Our Ref: DOC17/500171

RE: Heritage Council comments on MP06_0037 MOD 5 – Modification request Marine Refuelling and Supply Facility, Berth 6, White Bay, Balmain

Dr Thomas Richards
Acting Manager, Conservation
Heritage Division
Office of Environment and Heritage
9 November 2017

Figure 1.3 Proposed finger pontoon (circled in yellow) (figure: EMM Consulting Pty Ltd).

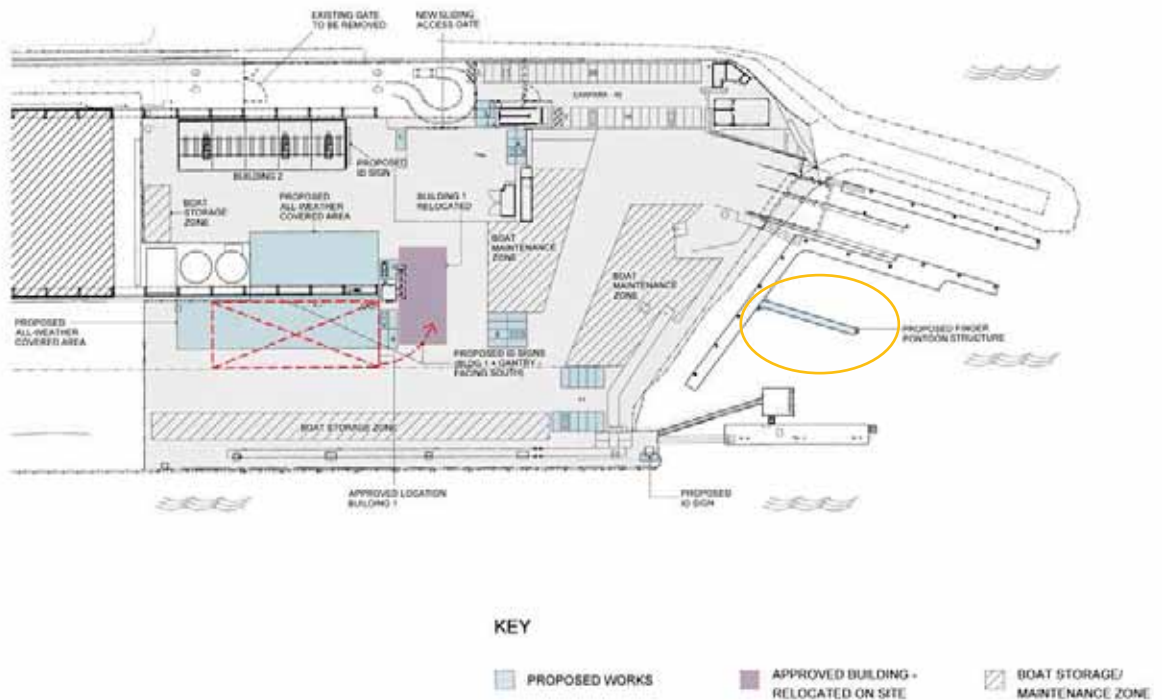
- The proposed works include the construction of a new floating finger pontoon and pile attached to the existing Marina. The sinking of this new pile will have a direct impact on the seafloor. However, the EA does not assess the impact of the new pile on potential shipwrecks or submerged maritime heritage sites within the study area. A desktop assessment was undertaken including the review of relevant heritage registers, however, the NSW Maritime Heritage Database does not appear to have been searched. It is recommended that any future modification proposal involving impacts to the seafloor should be supported by an EA which addresses impact to potential maritime heritage sites including a search of the maritime heritage database.
